Application number: 2023/93000	
What is the application for?:	Increase height of dry stone wall to 1.9m to rear (southern) and part of side (w
Address of the site or building:	11, West Nab View, Meltham, Holmfirth, HD9 5RY
Postcode:	HD9 5RY

Type of comment: An objection	
Do you wish your comments to be published on the website anonymously?	No

Impression of proposed wall height increase, continuing at 1.9m high for 2m from the corner and then sloping down to current original height of wall. Thickness of base of wall on corner to be increased into the plot as required to support height.

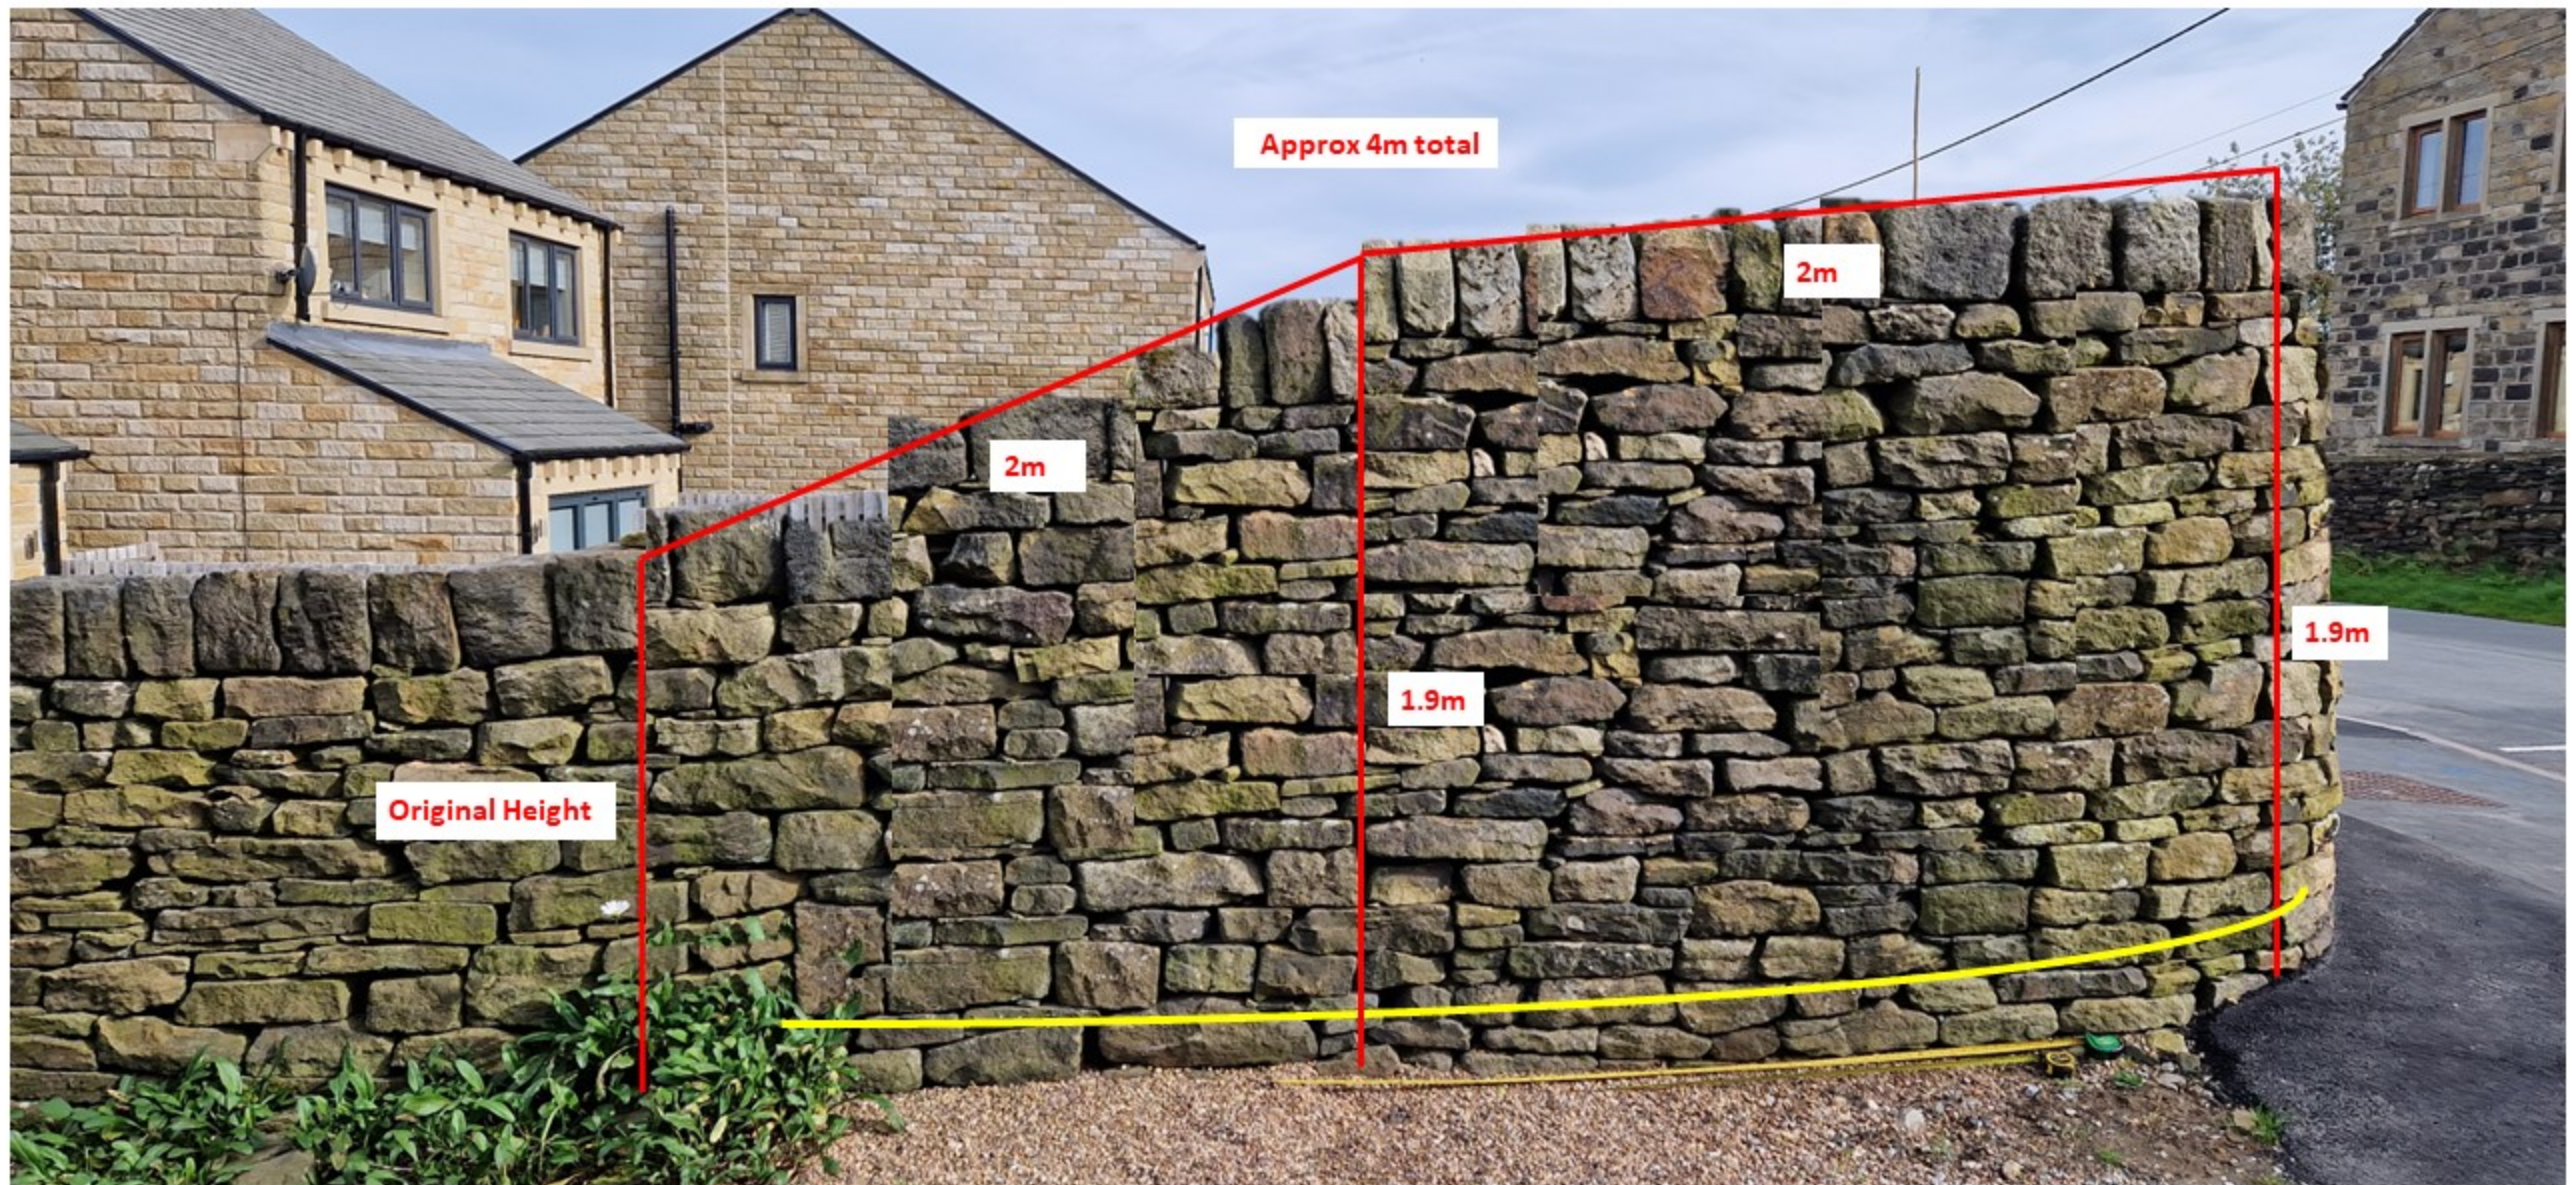
What it looks like. The materials chosen are very much in keeping but the height is not. There are no other stone walls of this height in the immediate vicinity, nor down the road to the village where there are both dwellings and access roads for vehicles and pedestrians, as is the case here. The wall used as an example in the application is in the opposite direction, towards the moors, is more rural in aspect being in the green belt, has no surrounding dwellings and no access tracks for vehicles coming off it, so the impact is not comparable to the position of the wall in this application. In this location, a wall of this height is not in character with its immediate surroundings and it is overbearing in nature, nor does it pay credence to the restoration of the site after building was completed.

Neighbouring properties. No's 102, 104 and 106 Mill Moor Road sit alongside one side of this wall. These houses are significantly below road level and significantly closer and lower to this wall than other dwellings in the area, at only 17ft away from the front doors. Sitting immediately opposite a portion of this wall is No 104. Any increase in height would have a greater impact of No 104 than any other dwelling in this area. No 106 is lower down than the proposed height increase so is unaffected. No 102, sits on the corner and is barely impacted as it has a clear view down the road to the village. However at No 104 the CURRENT wall height covers 1/2 the view from the front room window. At the point in question, this would increase to at least 2/3rds of the view being blocked by a stone wall. I consider this to be overbearing and it greatly restricts the light available to the room. This proposed wall height also severely restricts the view of the surroundings from the front of the house, reducing the ability to have natural surveillance of passers-by and approaching traffic. I can submit photos if required.
